**From:** Lyndsey Hayes  
**Sent:** 28 February 2024 13:44  
**To:** Lyndsey Hayes  
**Subject:** Tilia Homes response to LLFA objection

**From:** [REDACTED]  
**Sent:** Monday, February 26, 2024 5:46 PM  
**To:**  
**Cc:**  
**Subject:** RE: Preston Road, Longridge  
**Importance:** High

Thank you for issuing through the LLF formal comments received on Friday 23<sup>rd</sup> February, in relation to our discharge of conditions application (Application No: 3/2020/0042). We have consulted with our engineering consultants at Lees Roxburgh and can confirm the following formal response to the comments received from LLFA as follows in **GREEN** text below, in relation to each respective condition:

Drainage Proposals

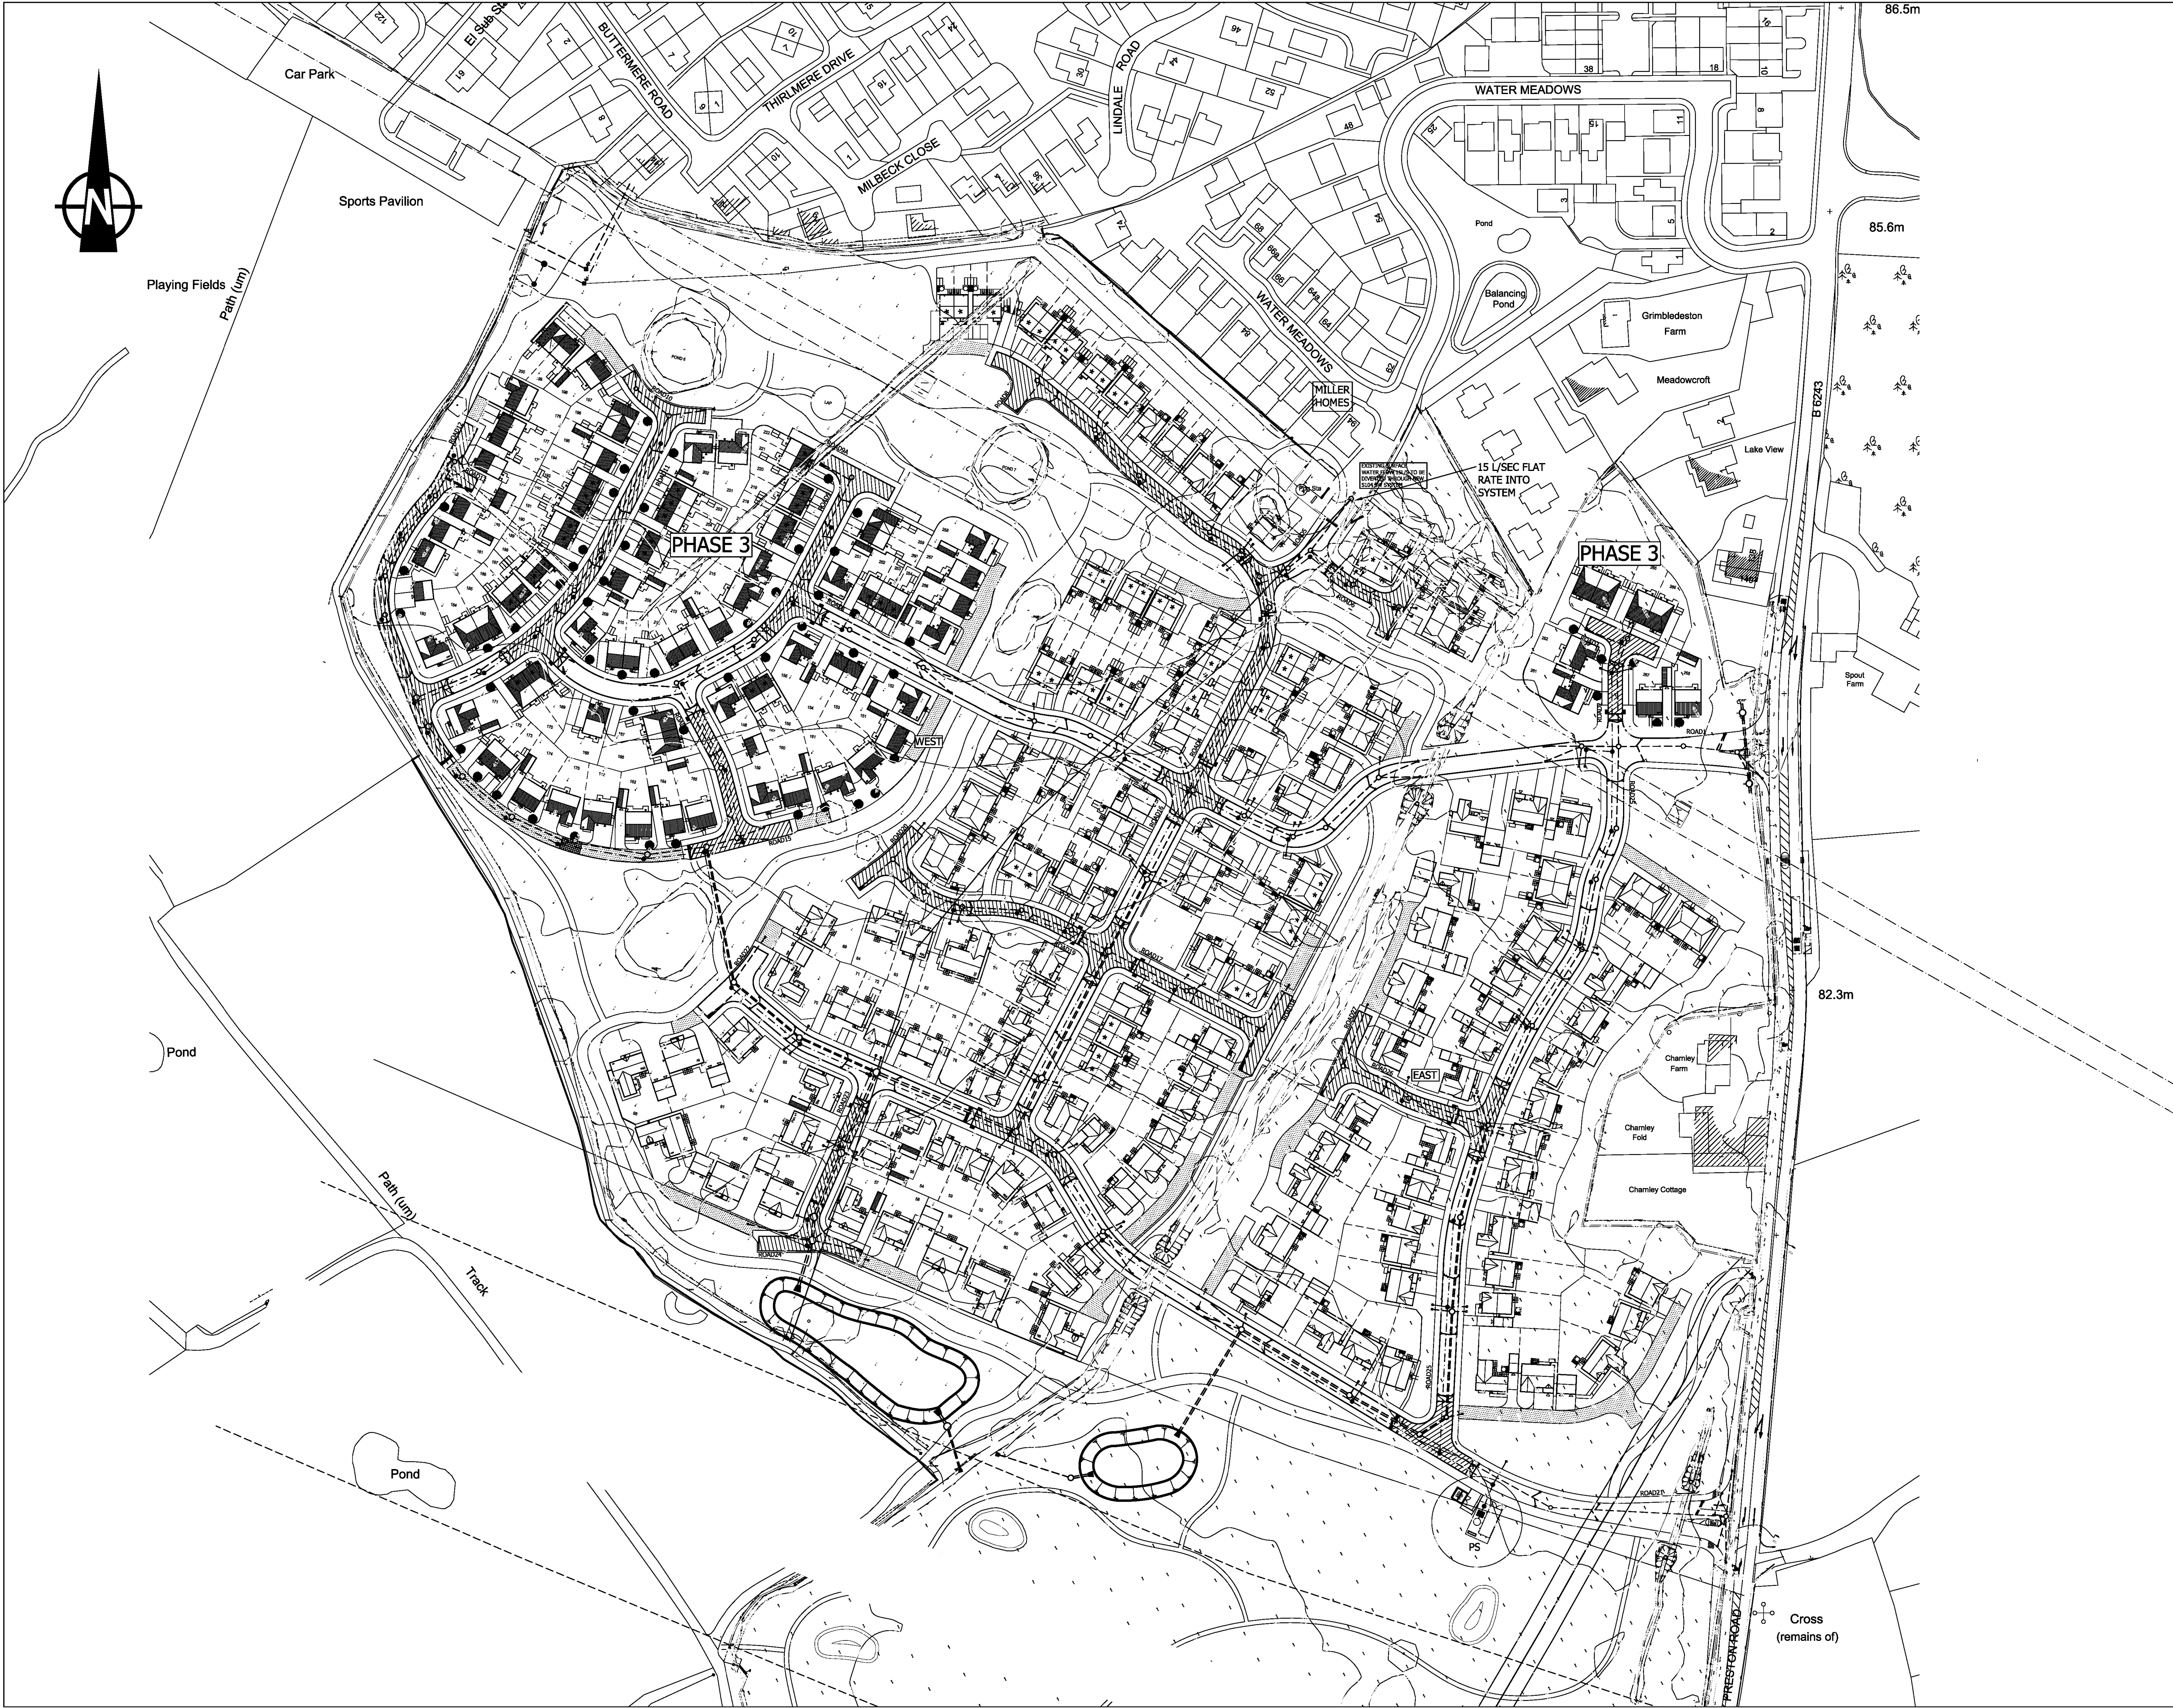
- *The applicant has failed to provide evidence of the sustainable drainage system layout showing all pipe and structure references, dimensions and design levels; to include all existing and proposed surface water drainage systems up to and including the final outfall. The adoptable drainage layout drawing fails to do this in its entirety.*

The attached full engineering pack seeks to fully detail the Phase 3 connections to the network serving the earlier phases.

Phase 3  
Section 38 Layout

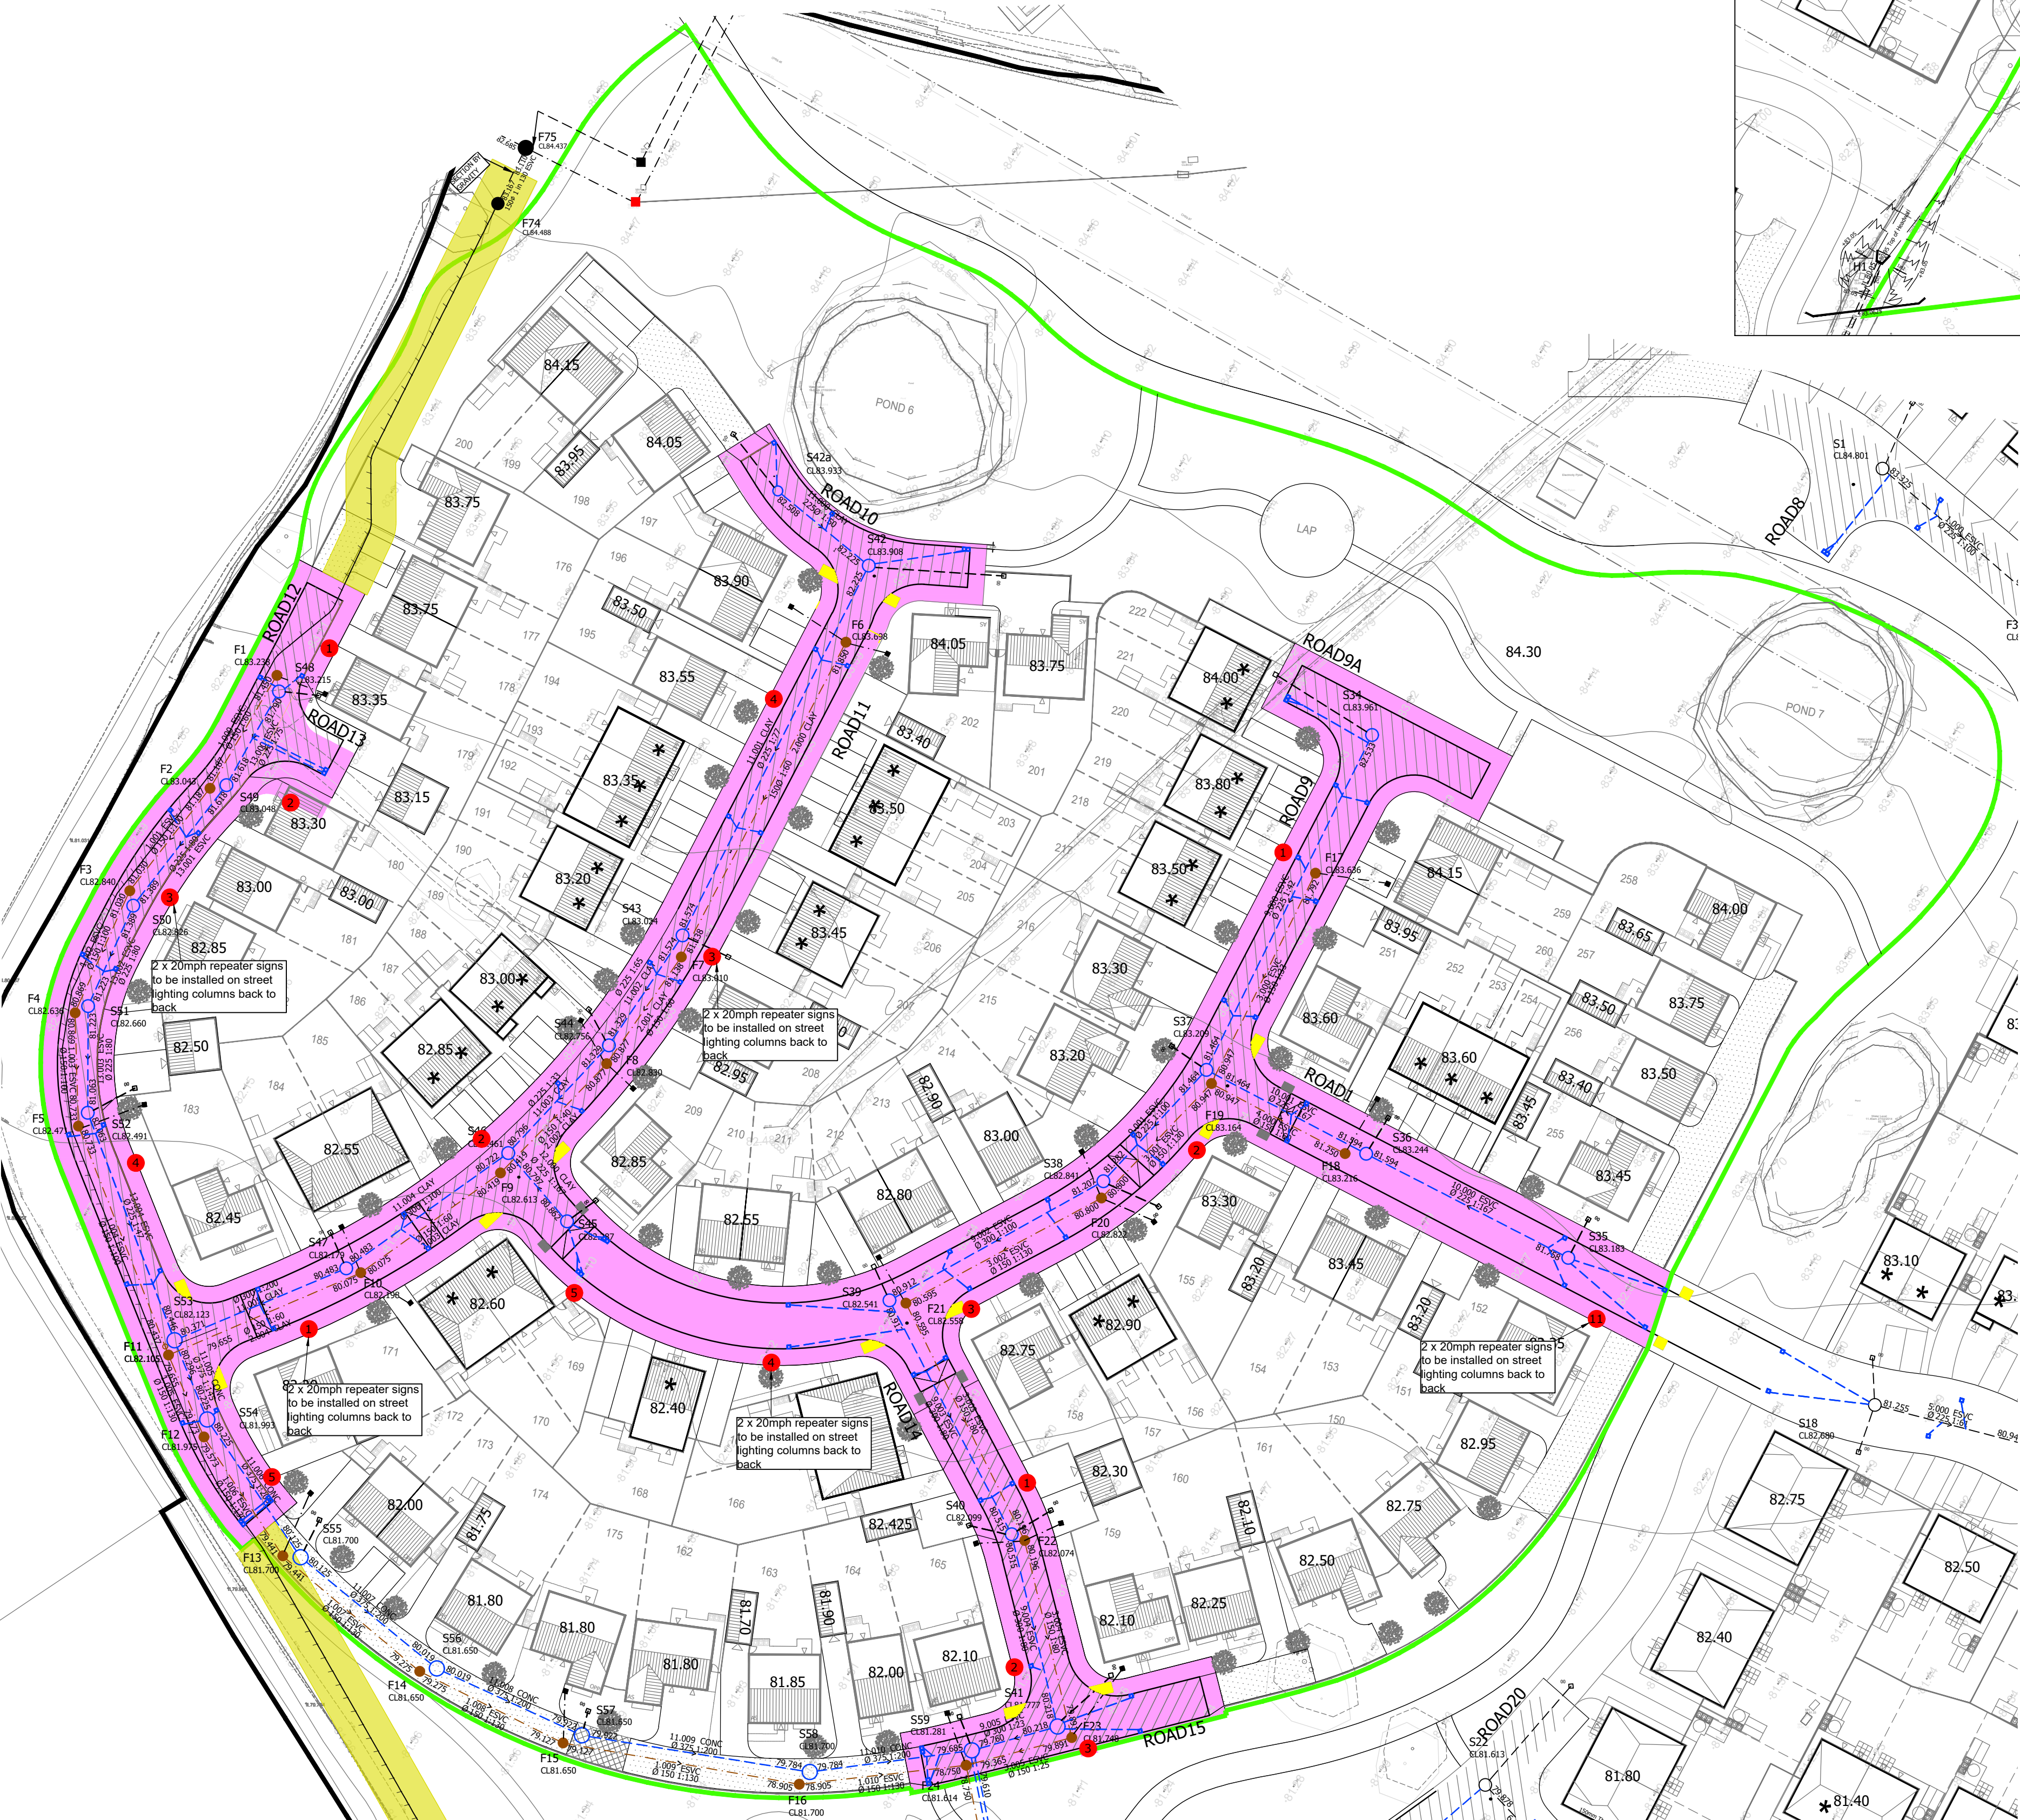
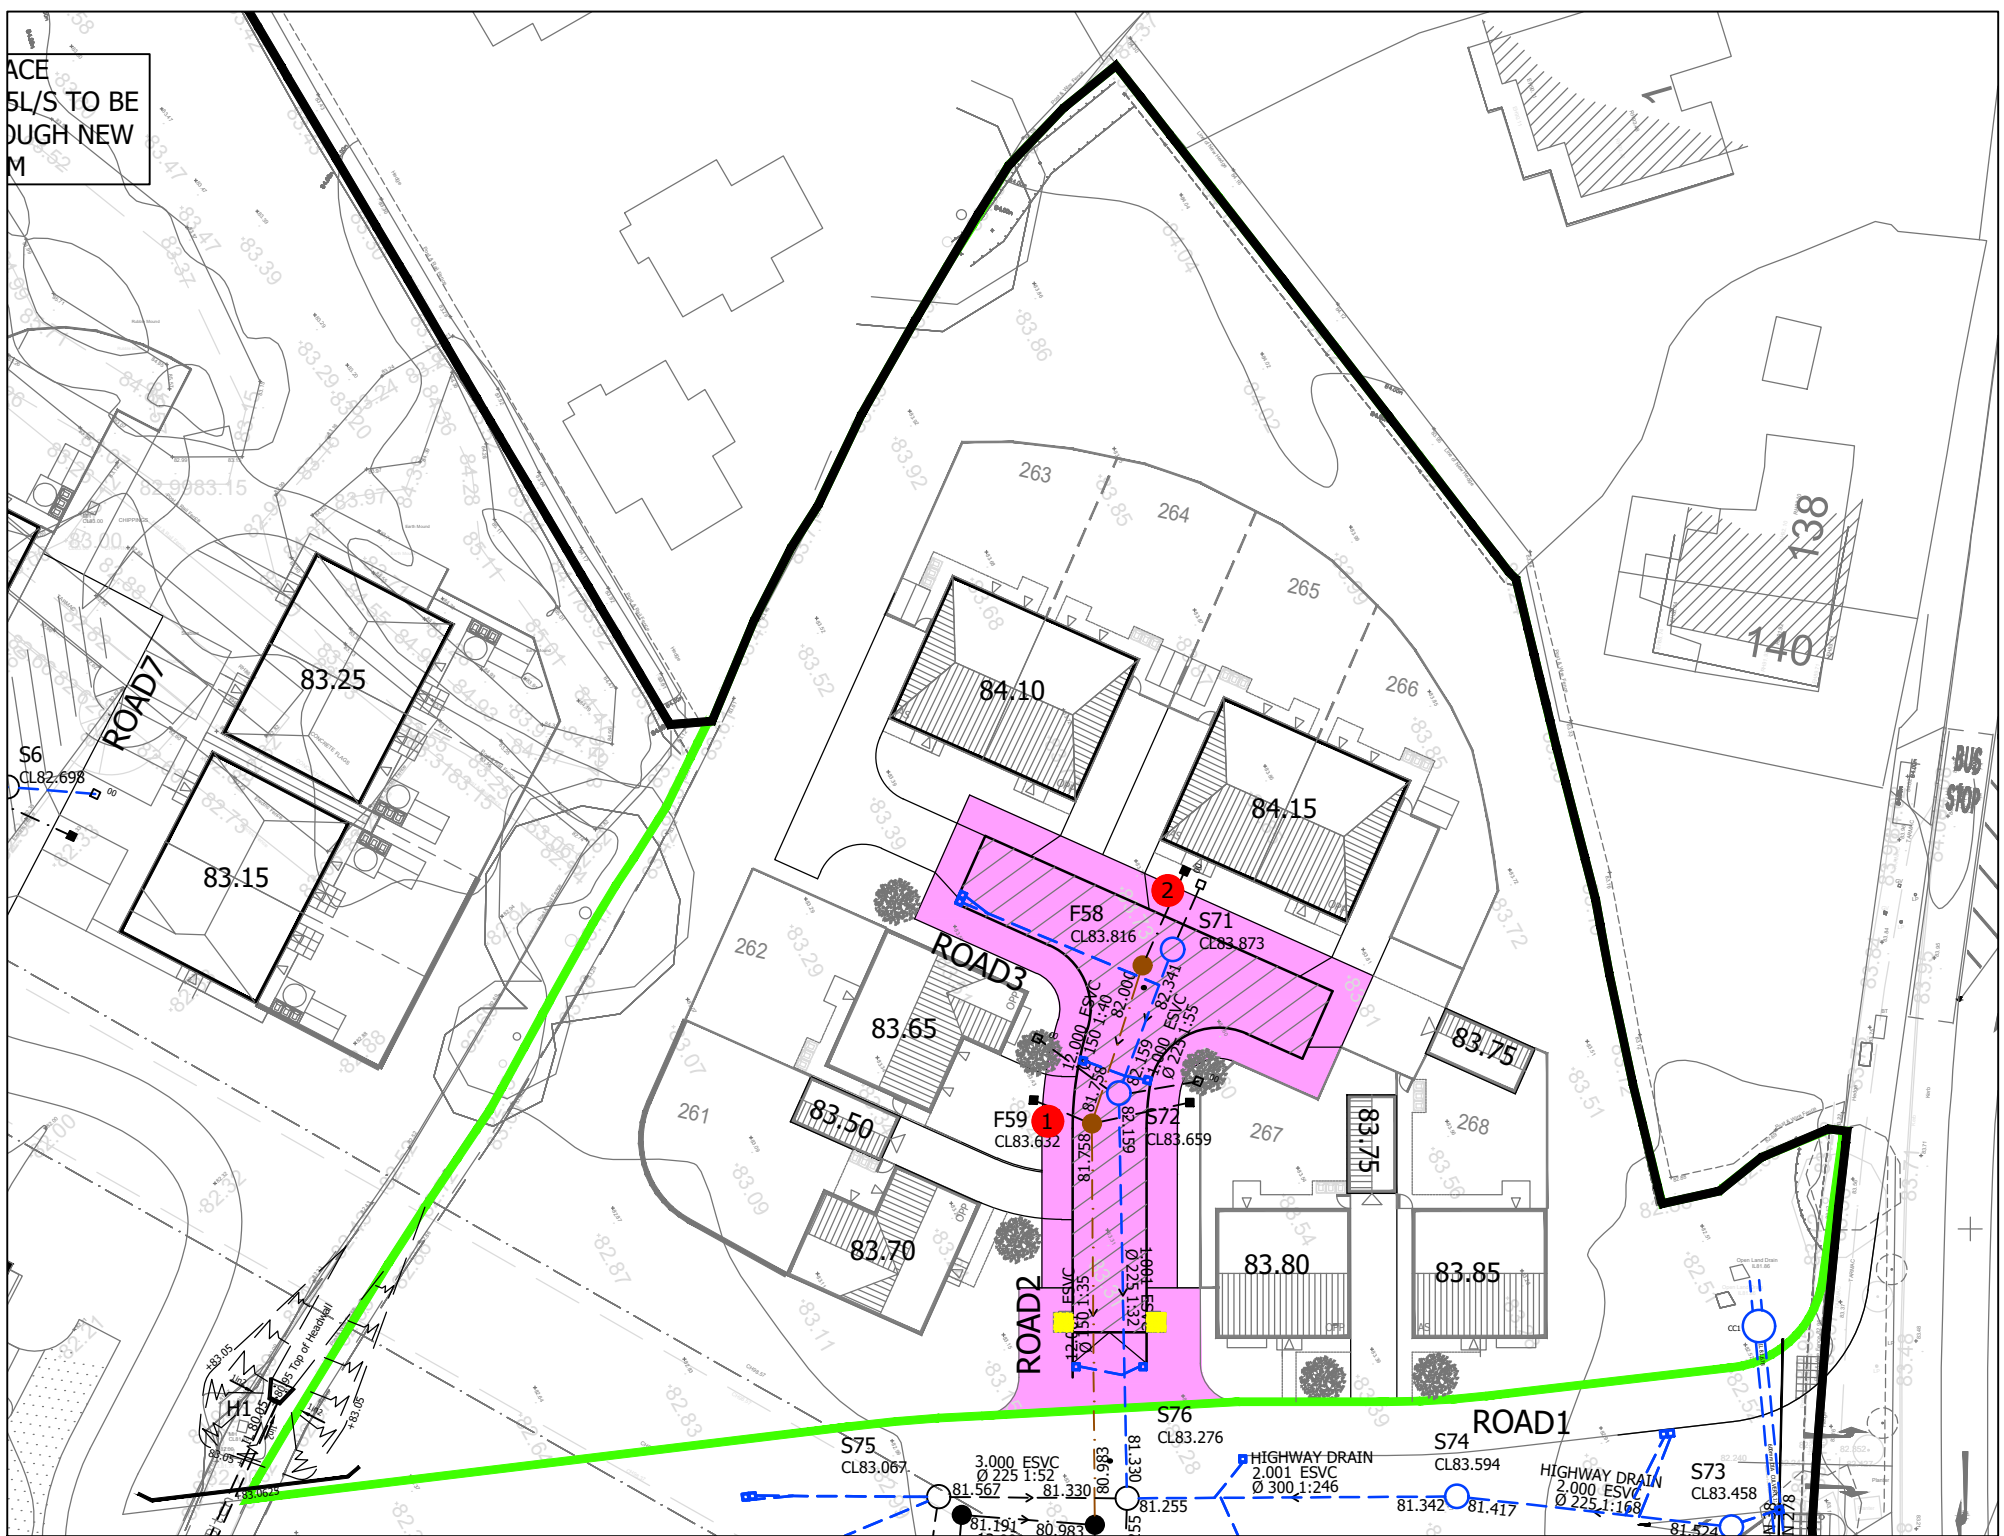
- *The applicant has failed to provide information outlining the timetable for implementation for the management and maintenance of the drainage arrangements.*

The already issued **Phase 3 Adoptable Drainage Plan Rev C (6196-300-03)** confirms that all proposed SW drainage will be adopted by United Utilities. The connection from Phase 3 is being made into the existing piped drainage network to the NW corner of the development.
